DEVELOPMENT HEARING OFFICER (DHO)

PR-2018-001482

VA-2023-00368 – SIDEWALK WAIVER

REQUEST: SIDEWALK WAIVER TO ALLOW FOR SIDEWALK ON ONLY ONE SIDE OF EACH ROAD

**RIVERSIDE MOBILE HOME PARK**  
 2911 ERVIEN LN SW  
 ALBUQUERQUE, NM 87121

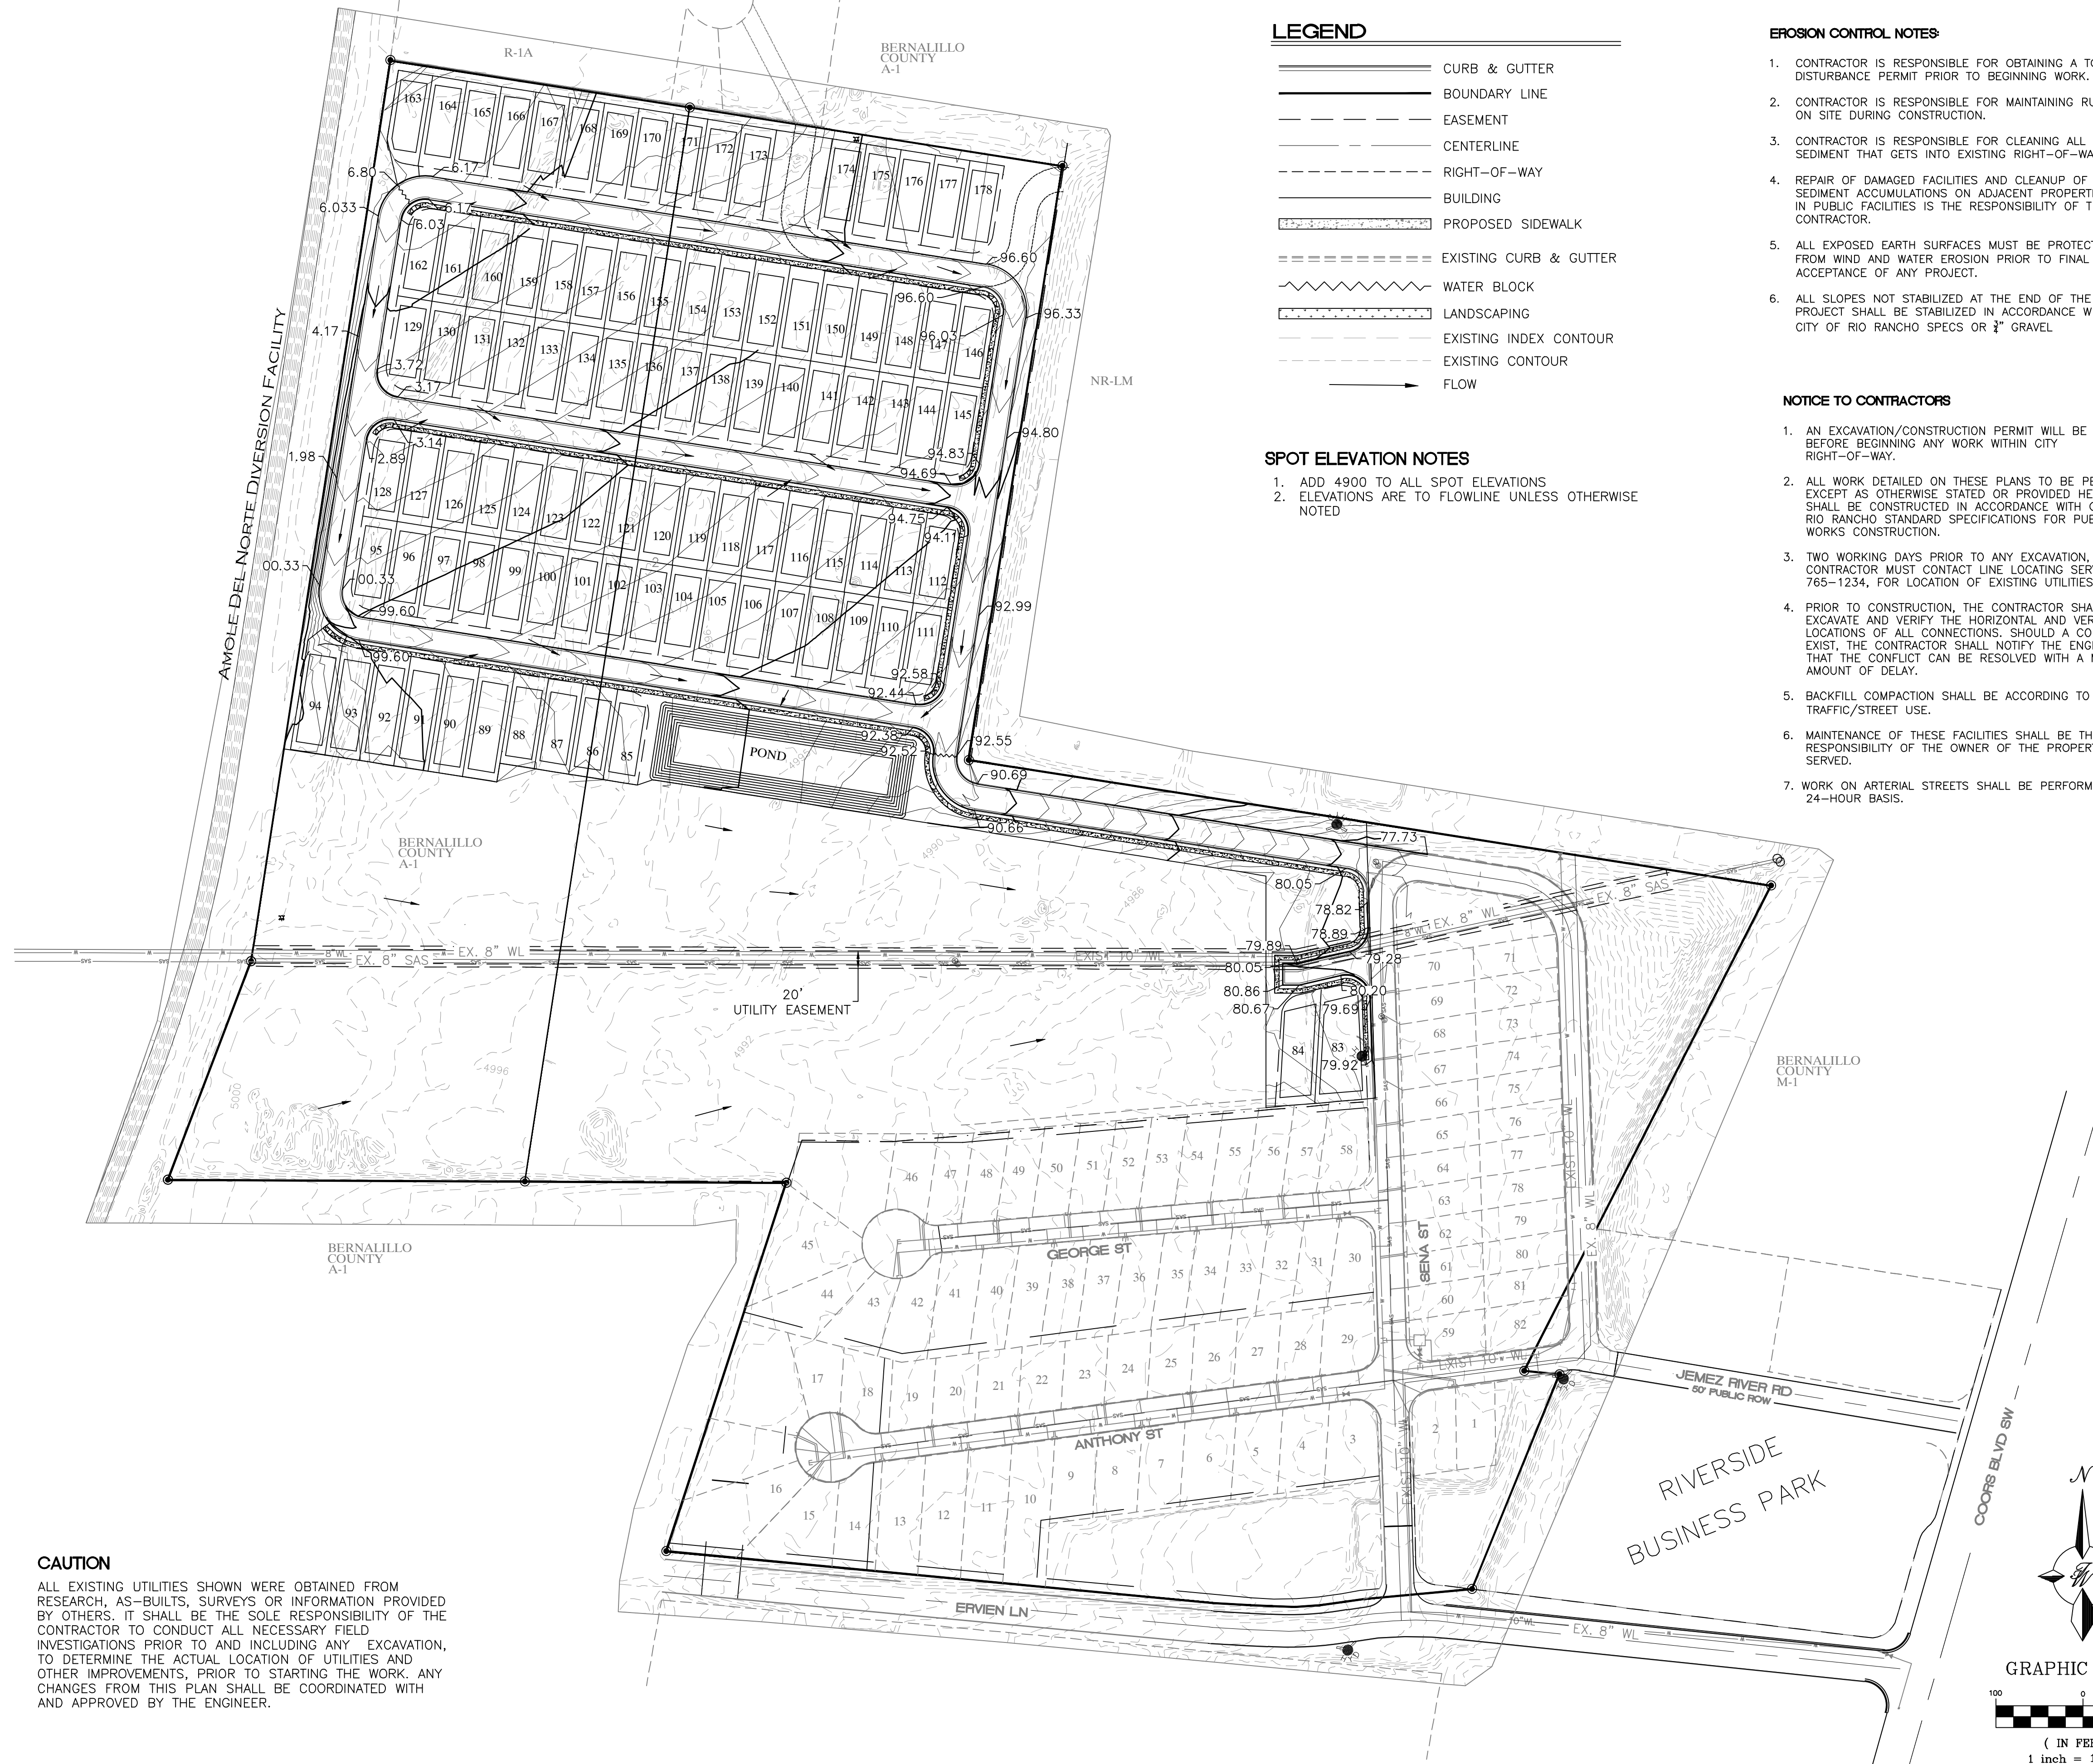
1. The justification for the sidewalk waiver is not acceptable. The sidewalks you have shown do not work as they do not provide access anywhere and the ADA corner ramps are in locations where there is no sidewalk to access across the street.
2. For plat, internal roadways will be local roads and must meet ROW indicated in the DPM and will require 5' sidewalks along both sides of the road. All work done in the ROW will need to be on an infrastructure list and be done through City work order.
3. An approved TCL will be required prior to site plan.

Check for compliance with DPM Table 7.2.29 regarding sidewalk/landscaping requirements.

Please detail landscape/buffer zone and sidewalk widths.

Access clarification needed.

Local streets require 5ft Sidewalk(s) and 4ft-6ft Landscape buffer(s).
